2024/0407

Cladding remediation to replace existing cladding panels with suitable compliant materials in line with current legislation

Skyline Flats, Heelis Street, Barnsley, S70 1DL

1 Proposed_Elevation - John-St
1:100

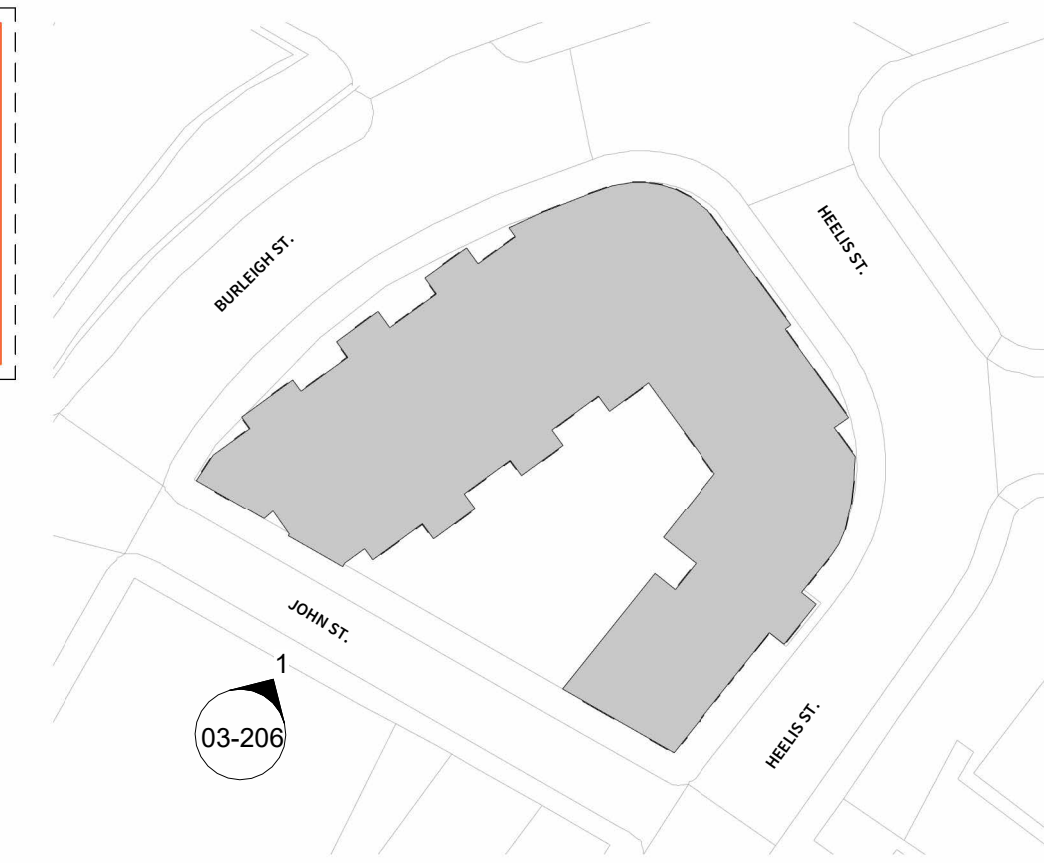
Urban Design Officer – Verbal comments received in relation to the orientation of the cladding panels, as significant work was undertaken during the determination of the original application in order to achieve the current design
Pollution Control – No objections
Ward Councillors – No objections received

The comments of the Urban Design Officer have been taken into consideration and referred to the applicant/agent. The colour of the panels are to match those used in the construction of the original building and the horizontal banding of the panels will be regularised to harmonise with the heads and cills to avoid awkward panel cuts and clashes which is currently the case. The detailed layout will be subject to approval via condition once the cladding contractor has been appointed.
